From: Anita Gardner
Sent: 06 February 2019 17:44
To: Karen Parsons
Subject: FW: 1 ARCADE RD REF: LU/310/18/PL

DWG. NO / 021018 / TP.02

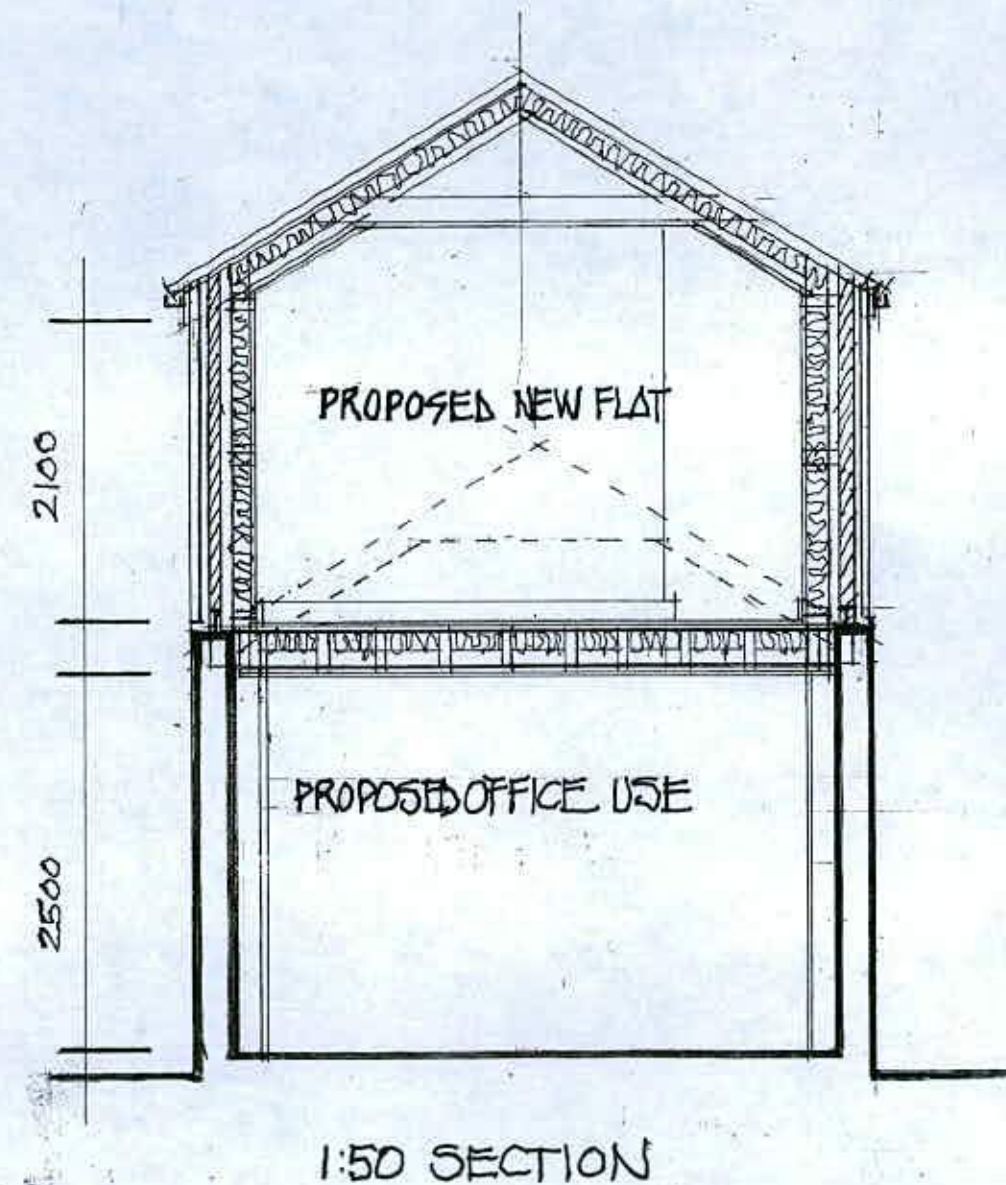
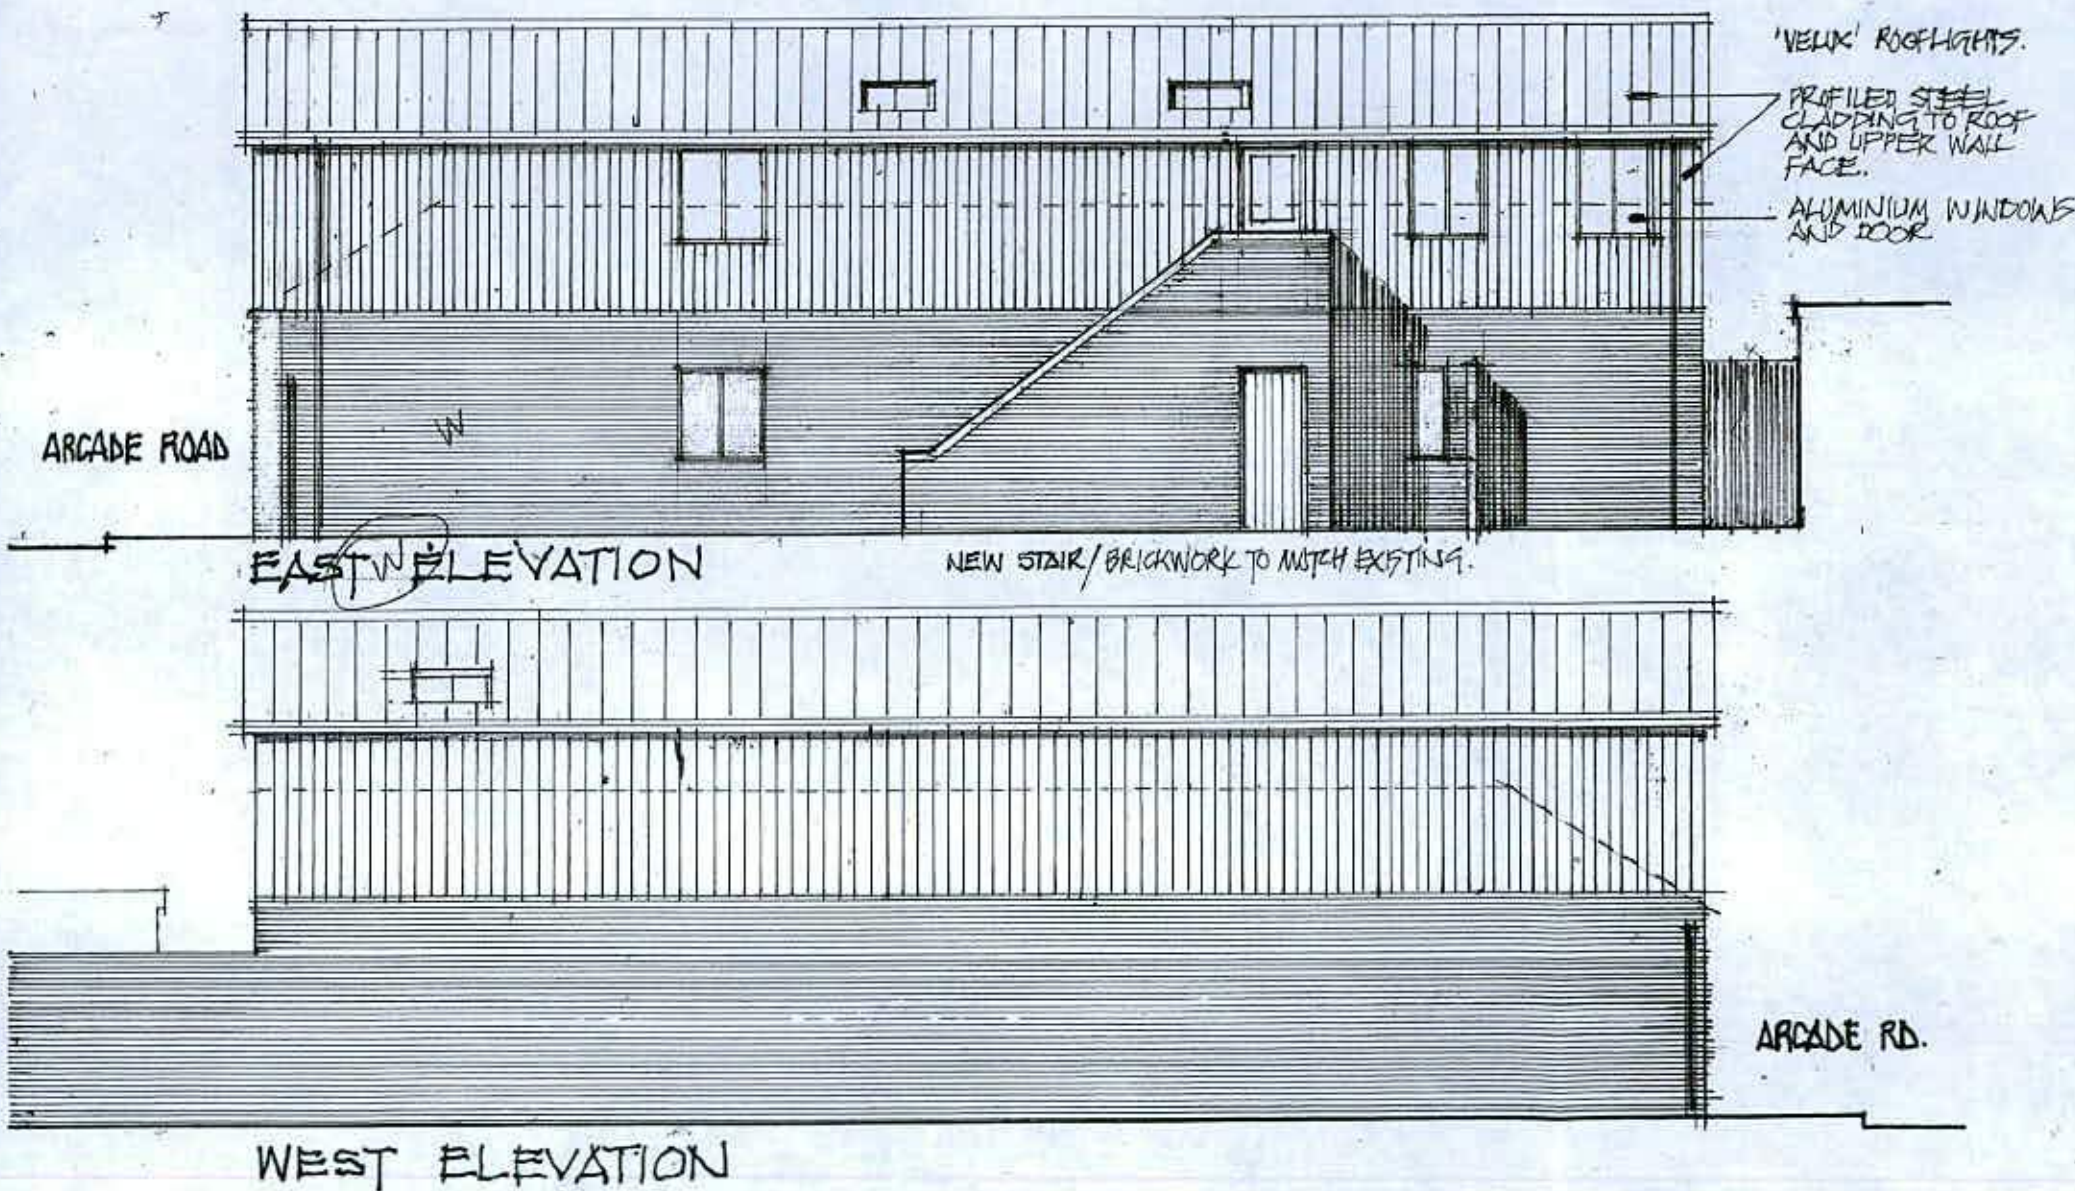
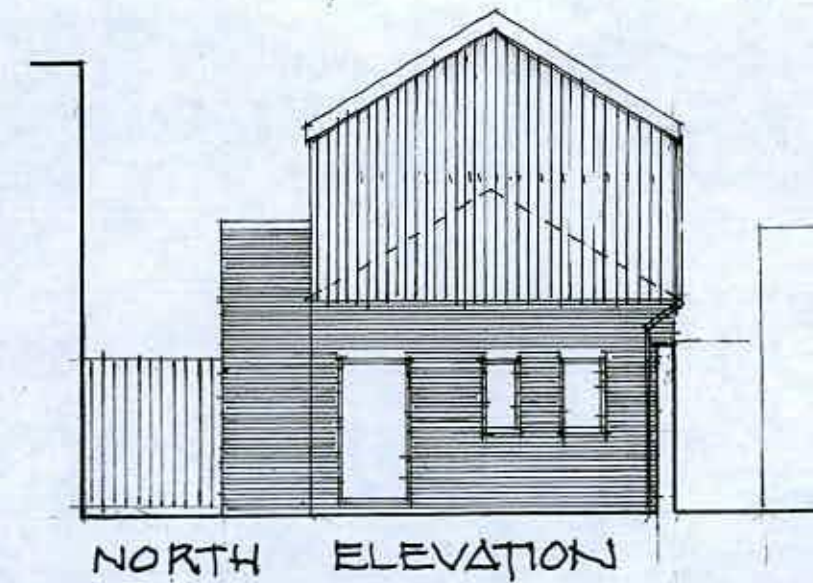
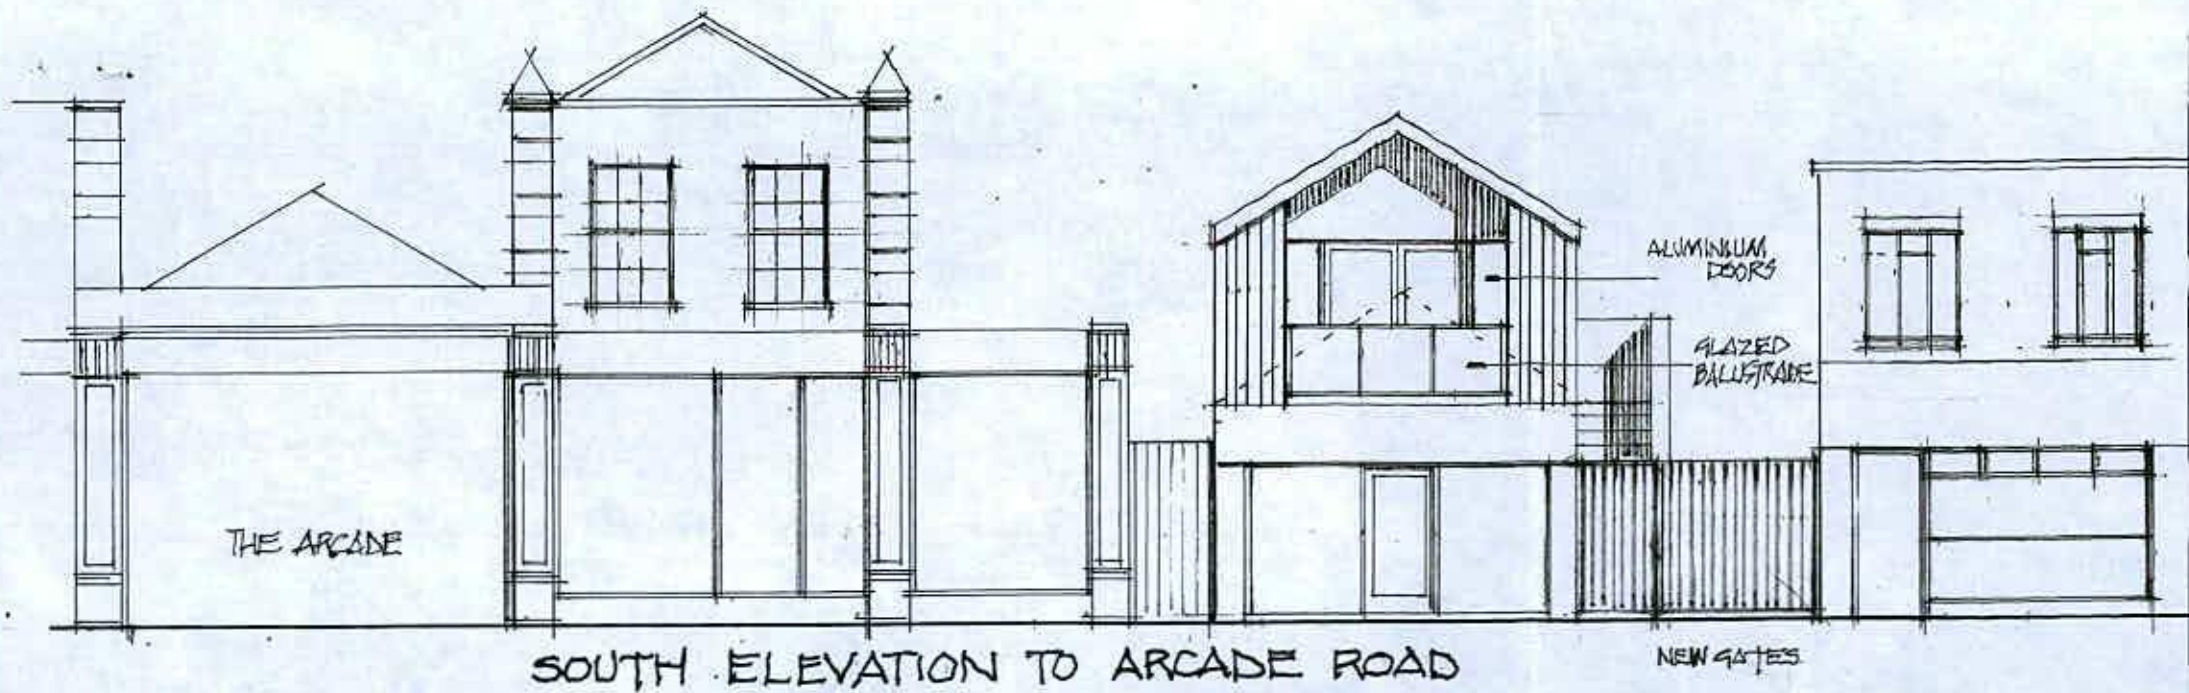
I note the comments of the Conservation officer and agree that the proposed materials for the elevations and roof are not appropriate in this location and I would suggest that these are deleted from the elevation so that they can be conditioned on any approval.

Meanwhile do you want replacement drawings removing the references to external materials or can this be dealt with in the wording of your condition?

If the suggested sheeting is a problem we could consider mineral horizontal slate coloured boarding to the elevations.
